Recommendation Report for Planning Permission for Works or Extension to a Dwelling

REF NO: LU/139/21/HH

LOCATION: 5 Shannon Close
Littlehampton
BN17 6PR

PROPOSAL: Installation of a first floor rear balcony

PLAN VIEWS OF FLAT ROOF
OF REAR EXTENSION CONVERSION LU/139/21/HH
Scale 1:100
Drawn by R GATCHER DATE 8/6/21

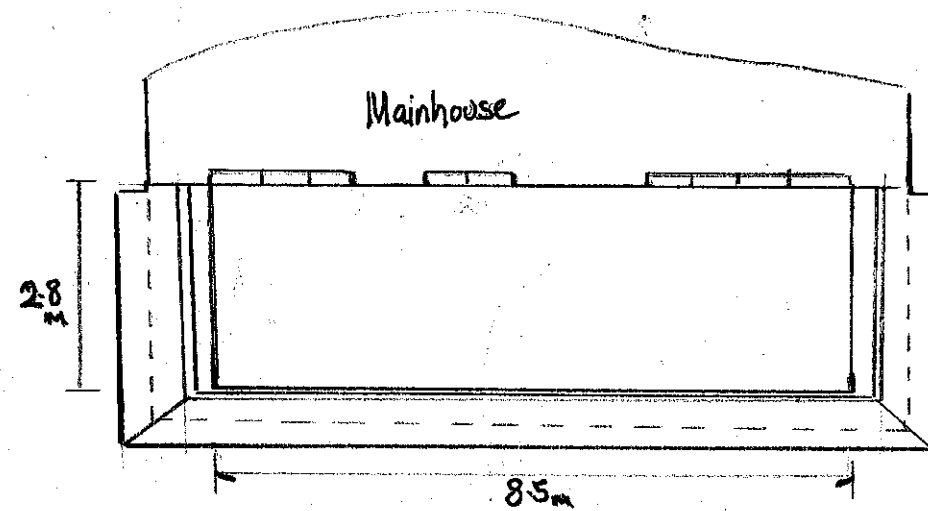
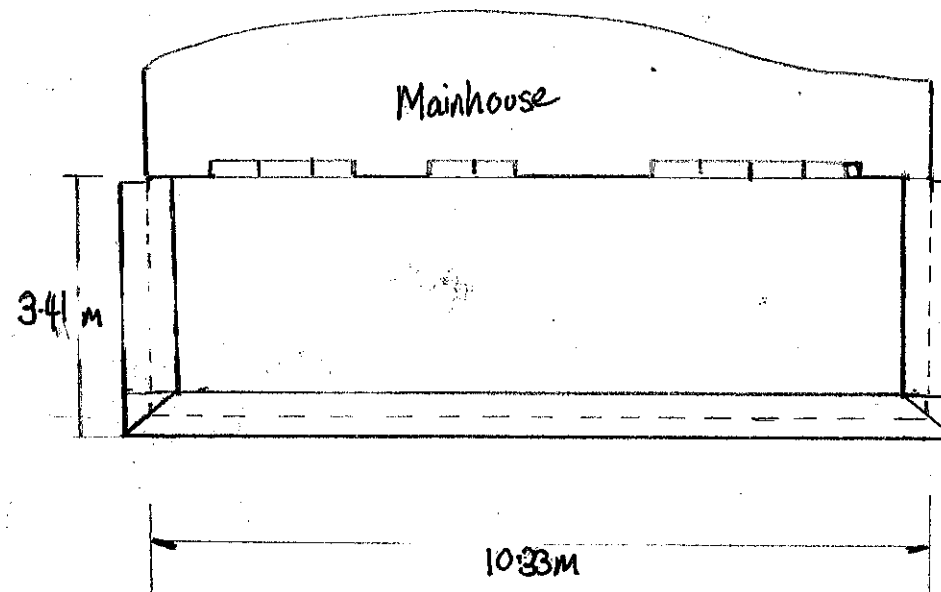
The proposed balcony would run almost the full width of the existing house to a depth of 2.8m, utilising an existing flat roof to a rear extension. It is noted that there exists 3 sets of casement windows to the rear elevation of the house which serve the bedrooms of the property, including the master suite. It is proposed to increase the depth of the window serving the master bedroom to allow for patio doors and full length side lights to be installed, giving access onto the proposed balcony. The alterations to the fenestration will not increase overlooking to adjacent properties, especially as the neighbouring property to the south-east, nearest the patio doors, is set slightly forward of the rear building line of the host dwelling.

Proposed elevation - 1st Floor Balcony

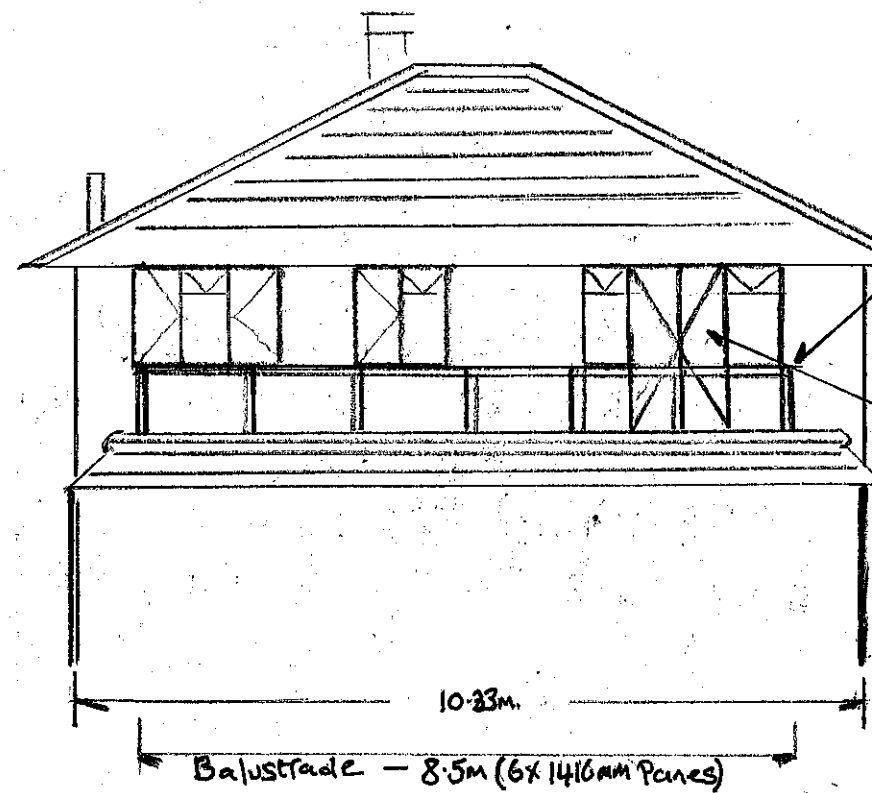
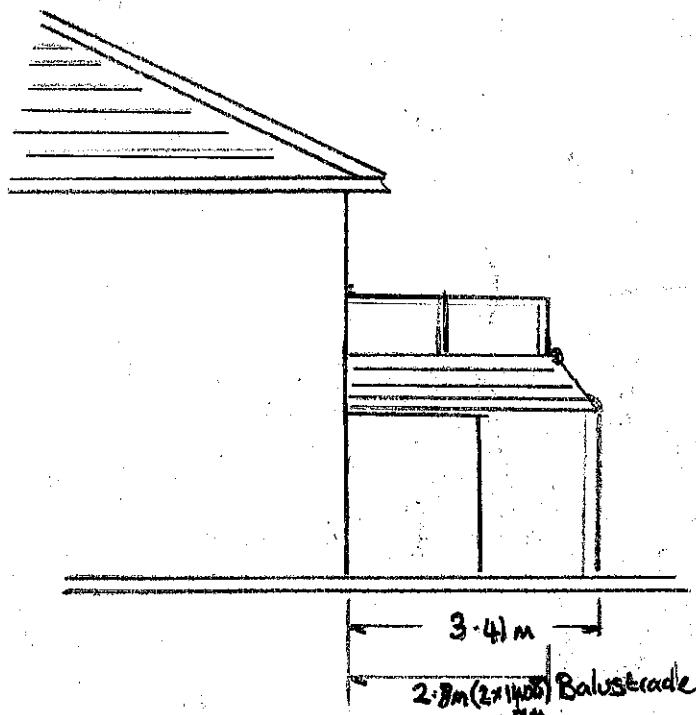
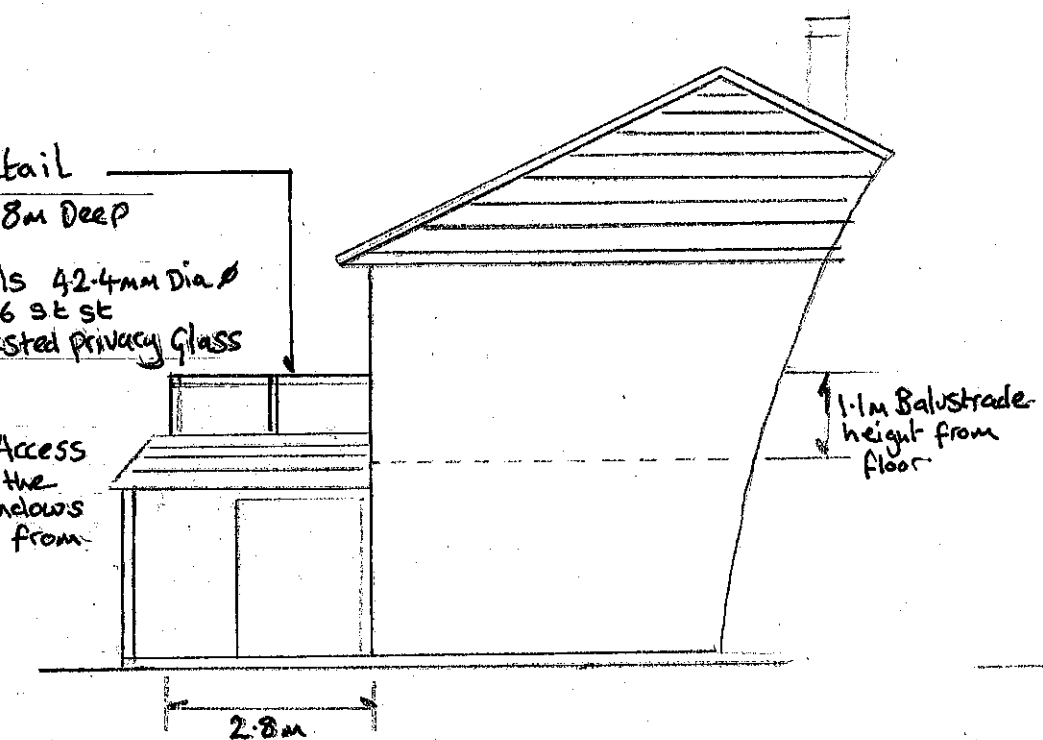
The site sits on an irregular shaped plot at the head of Shannon Close, meaning that the rear boundary is at an acute angle to the rear line of the house. The proposed balcony will provide the applicant with a large viewing platform across the backs of approximately 5 neighbouring properties, some will be affected more than others due to the irregularity of the shape of the site. At right angles from the rear wall of the house the boundary fence is located, at its closest point, approximately 5m away and at its

deepest point approximately 18m. This in turn leads to a direct viewing distance of approximately 4m to the rear boundary of 41 Tideway and a little over 6.5m to 43 Tideway, approximately 18m from the rear wall of No 41 Tideway. No measures have been proposed to lessen the impact on views into the neighbouring gardens of these two properties. As such, it is felt that the ease of viewing and the relatively short distance between the balcony and shared boundaries, that this will lead to unacceptable levels of overlooking and will negatively impact the privacy of No. 41 and 43 Tideway.

It is therefore considered by virtue overlooking neighbouring properties that the proposed extensions conflicts with policies D DM1 and D DM4 (c) of the Arun Local Plan.

- 1 The proposed new balcony on the rear elevation will result in unacceptable adverse impact in terms of overlooking of adjoining properties contrary to policies D DM1 and D DM4 of the Arun Local Plan.
- 2 **INFORMATIVE:** Statement pursuant to Article 35 of the Town and Country Planning (Development Management Procedure)(England) Order 2015. The Local Planning Authority
